## **Response to Planning Application**

**From:** Arun District Council Leisure & Greenspace

**Application ref:** WA/2/22/OUT

**Description:** Outline planning application with all matters reserved, other than means of access, for the construction of up to 48 dwellings (30% affordable homes) and dental/doctors' surgery (Use Class E (e)). This application may affect the setting of a listed building & may affect the Walberton Village Conservation Area.

Figure 04: illustrative masterplan

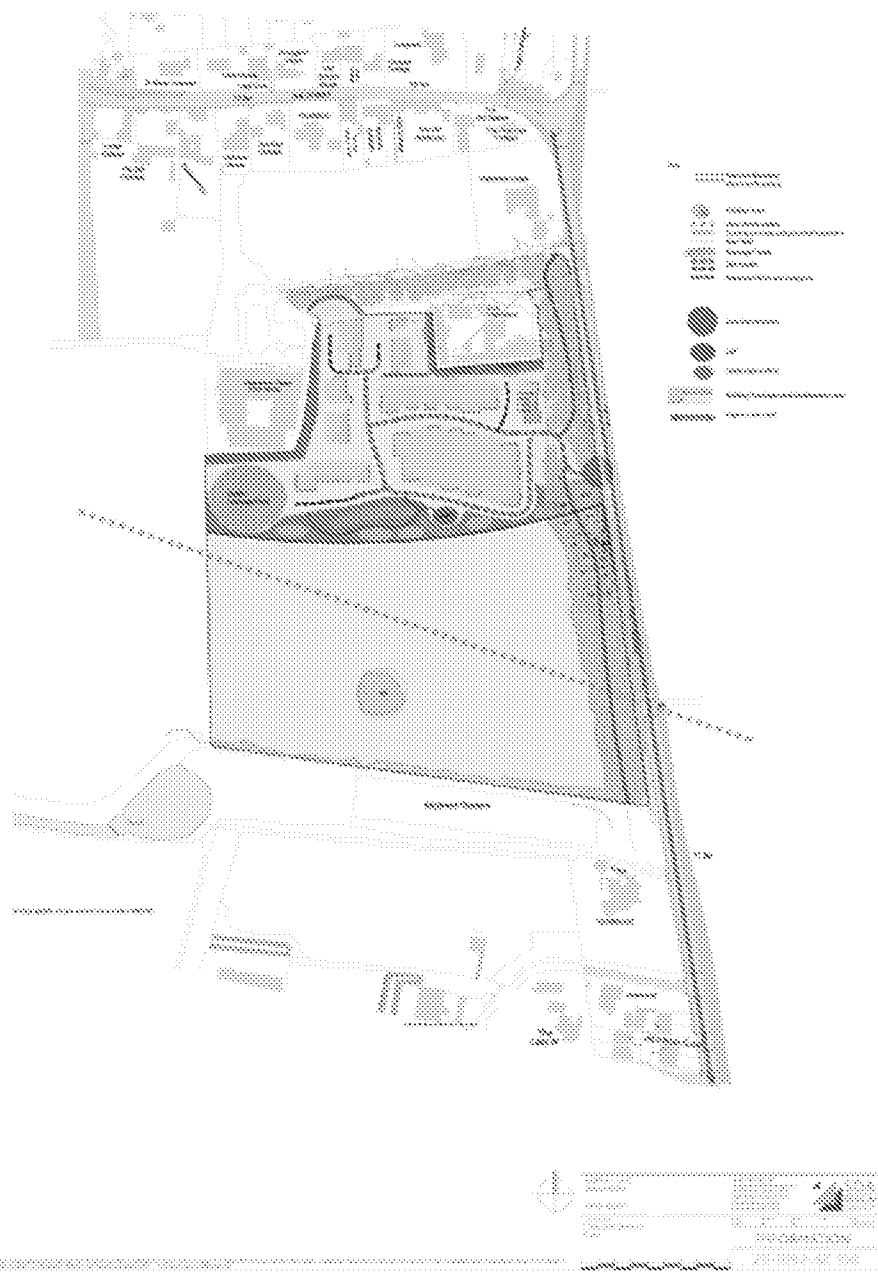
Quality, well-designed Public Open Space (POS) will be fundamental to any proposal submission, these will need to accord with Arun District Councils Open Spaces SPD January 2020. There would be requirement for confirmation of the areas of public open space being proposed with this development, and clarification re quantum. There would be a requirement for 3,960m<sup>2</sup> of usable POS provision excluding SuDS are to be provide with this application.

The open indicated are of POS would appear to be heavily dominant with SuDS features, it would need to be demonstrated that these do not compromise the POS available and existing vegetated tree buffers whilst providing green infrastructure for the proposed development should not be relied upon as serving the POS requirement.

This development will trigger the requirement for play in the form of onsite LAP and LEAP provision, **only one LAP is presently indicated which would not meet out SPD requirements**. Play would need to be suitable for location in material choice and play experience offer, be inclusive and accessible in line with the now adopted SPD 13 Arun District Design Guide January 2021. Off-site allotment contribution would not be triggered from a development of 48 units.

The application indicates the provision of potential dental/doctor surgery within the proposals. Adequate infrastructure would also need to be provided for this ie carparking, access and setting consideration in relation to dwellings. The Concept Layout does not adequately indicate how this would be integrated alongside these 48no residential dwellings.
